Qantas Flight Training Centre (SSD 10154) - Response to Submissions

Thank you for your correspondence dated 26 August 2019, requesting Transport for NSW (TfNSW) to review and comment on the above.

6.4m SMALL RIGID VEHICLE
SWEPT PATHS

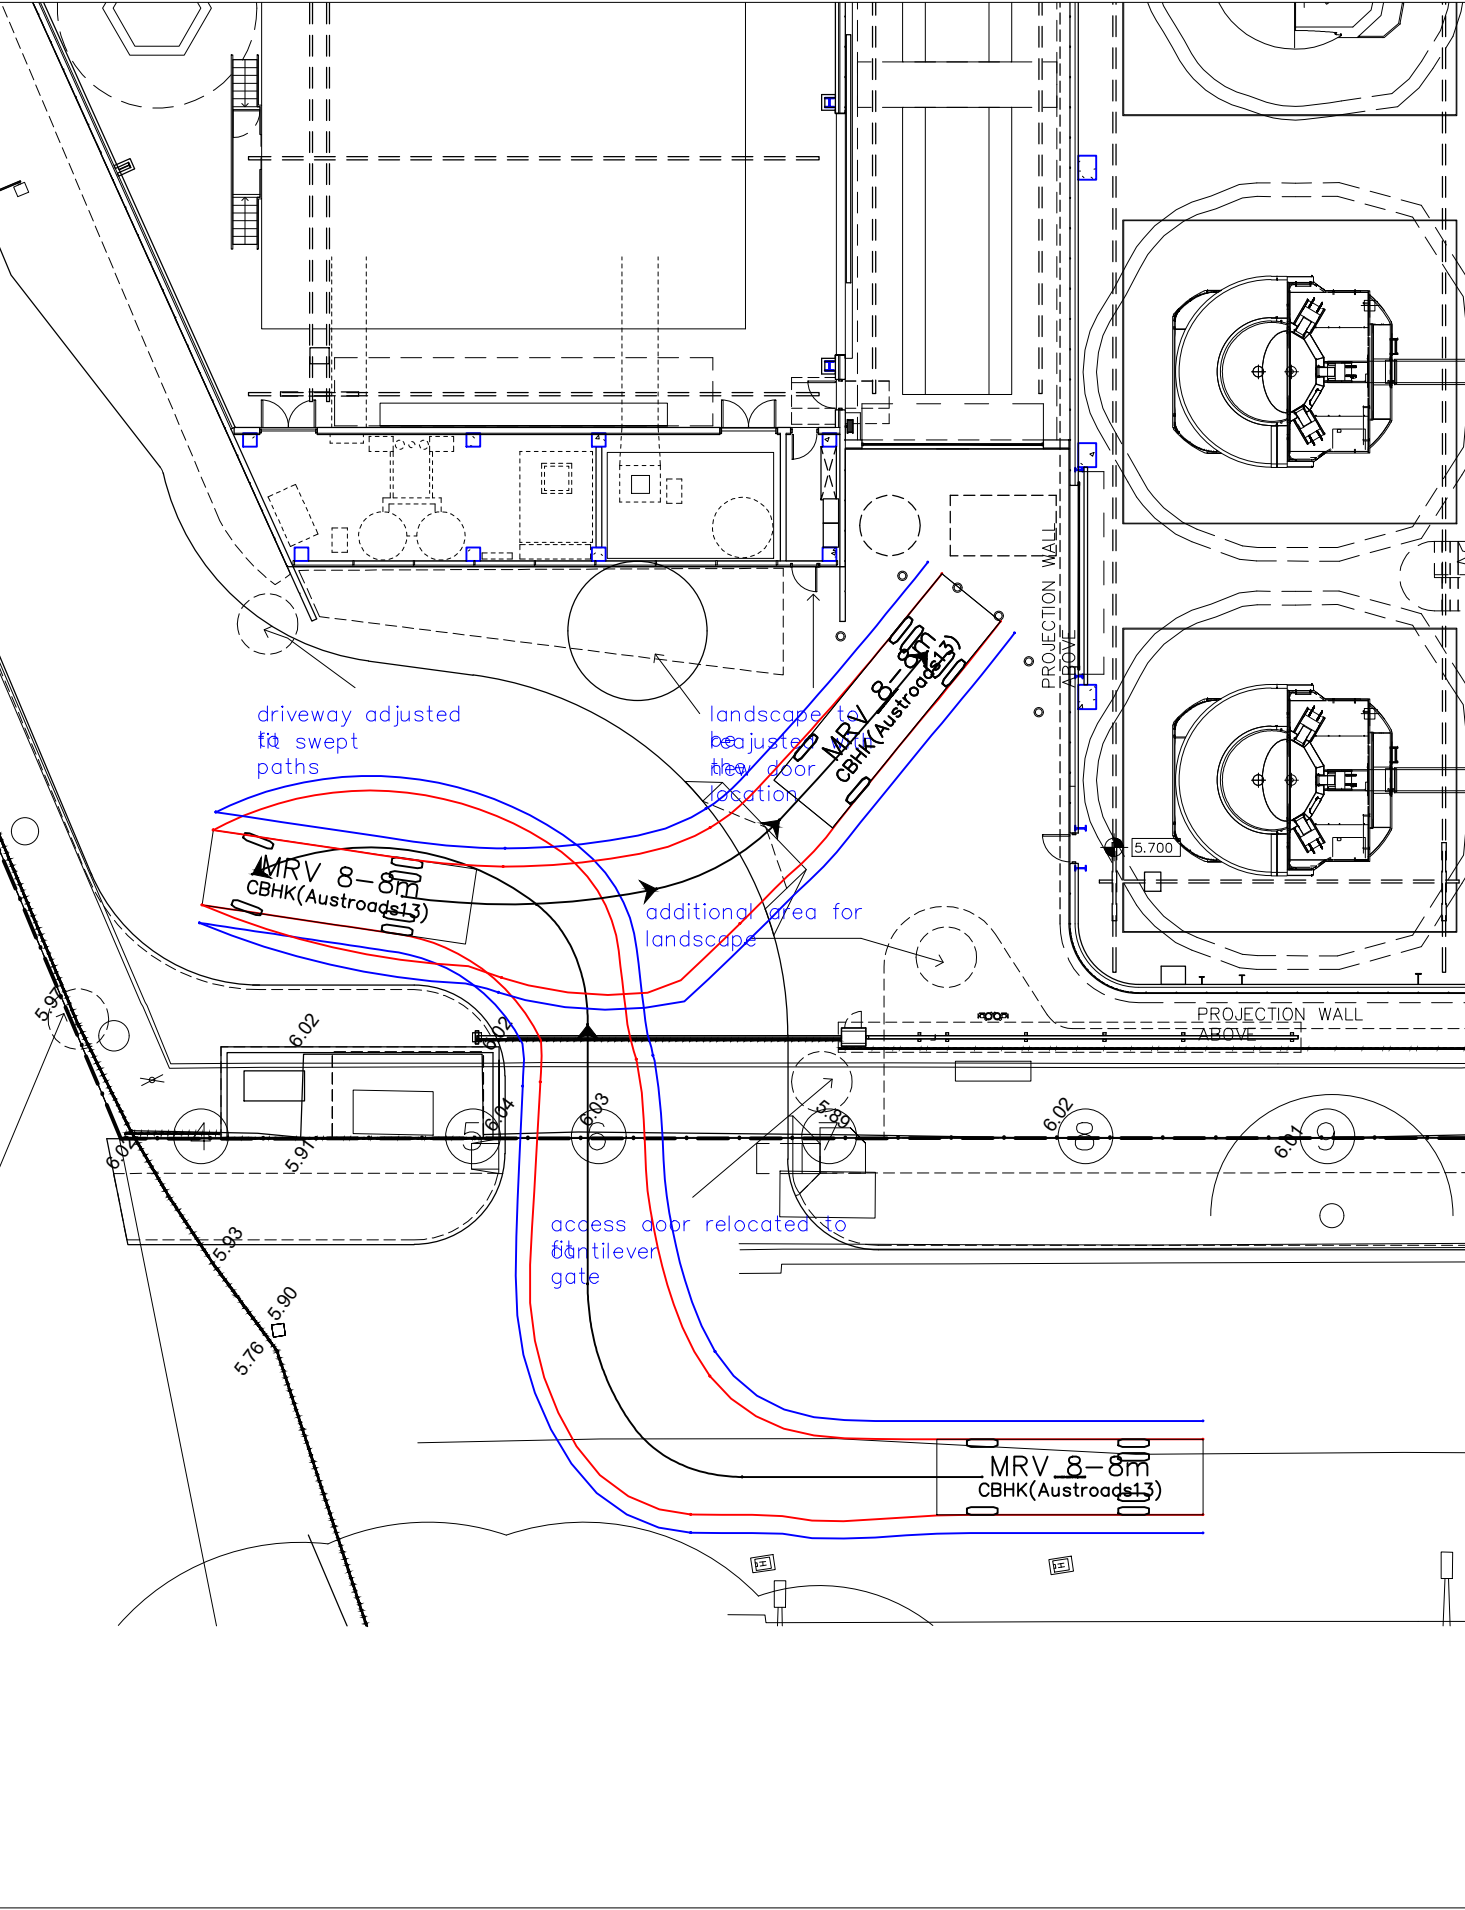
It is noted that the report mentions use of articulated vehicles. However, the swept path analysis includes a movement of a B-Double vehicle. If the proponent intends to run B-Doubles, a separate permit from the National Heavy Vehicle Regulator (NHVR) will be required. Any vehicle should arrive and depart the site in a forward motion.

It is requested that the applicant be conditioned to require all vehicles entering and leaving the site to do so in a forward motion. Note that if B-Doubles are intended to be used, a permit will need to be obtained from the National Heavy Vehicle Regulator (NHVR).

All vehicles entering and leaving the site shall do so in a forward motion. Note that if B-Doubles are intended to be used, a permit will need to be obtained from the National Heavy Vehicle Regulator (NHVR).
